Re: PA23-003 – Jennings Substation – Technical Review 1
7728 & 7808 47th Ave NE – APN(s): 30052100412500 / 30052100414500

SITE PLAN REVIEW COMMENTS

RE: Jennings Substation, File# PA23-003
New Power Substation
7728 & 7808 47th Ave & Parcel #'s 30052100412500 & 30052100414500

Proposal: Snohomish County PUD is proposing the construction of a new electrical distribution substation facility. The facility would include a substation yard, access driveway, and security fencing. Perimeter landscape screening is proposed along the north, east, and south boundaries.

REV	DRAWING
0	S-135-K4

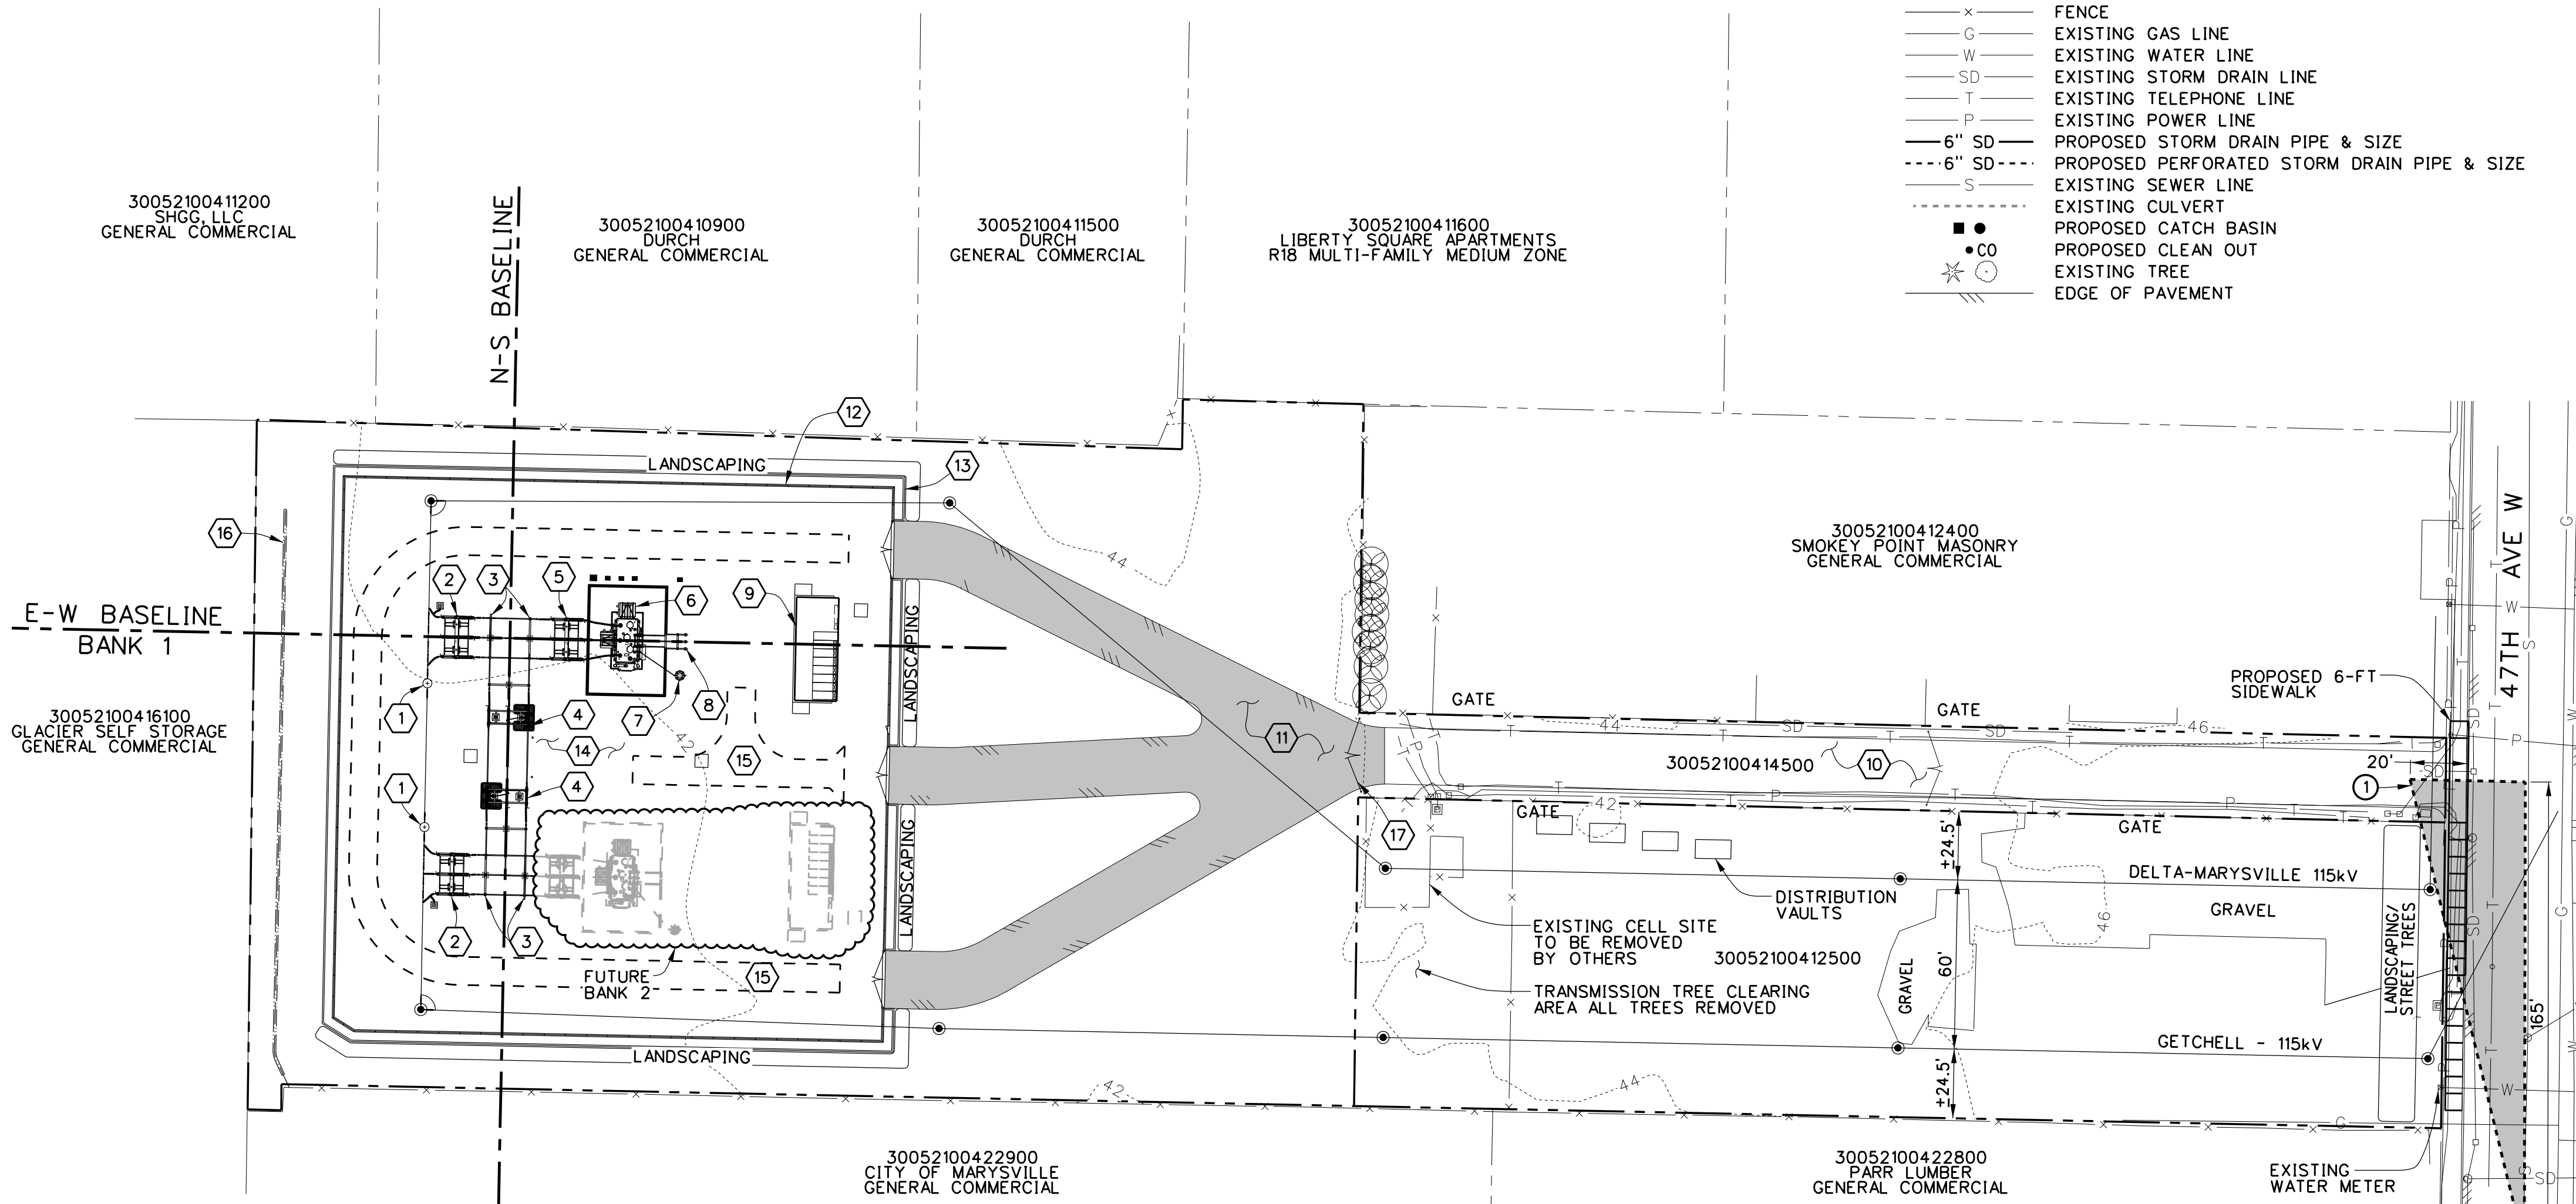
1. Include File Number PA23-003 on all future correspondence, in addition to all site, civil and landscape plans.
2. Being as the security fencing is to be 7ft. in height, a building permit would be required per [MMC 16.04.010\(4\)](#).

- a. The existing access for the home should be removed and the curb replaced. It would appear that because of ownership the project could gain access via the existing driveway on parcel 30052100414500. As the sidewalk is adjacent to the curb the sidewalks should also be replaced with a 6 foot sidewalk. The project is proposing the requested 6 foot sidewalk.

4. **Dedication Requirements:**
 - a. It does not appear that additional right-of-way is required for 47th Ave. NE.
5. **Access:**
 - a. The proposed access appears to align with the roadway across the street, there is an existing access on parcel 30052100414500 which should be utilized if possible.
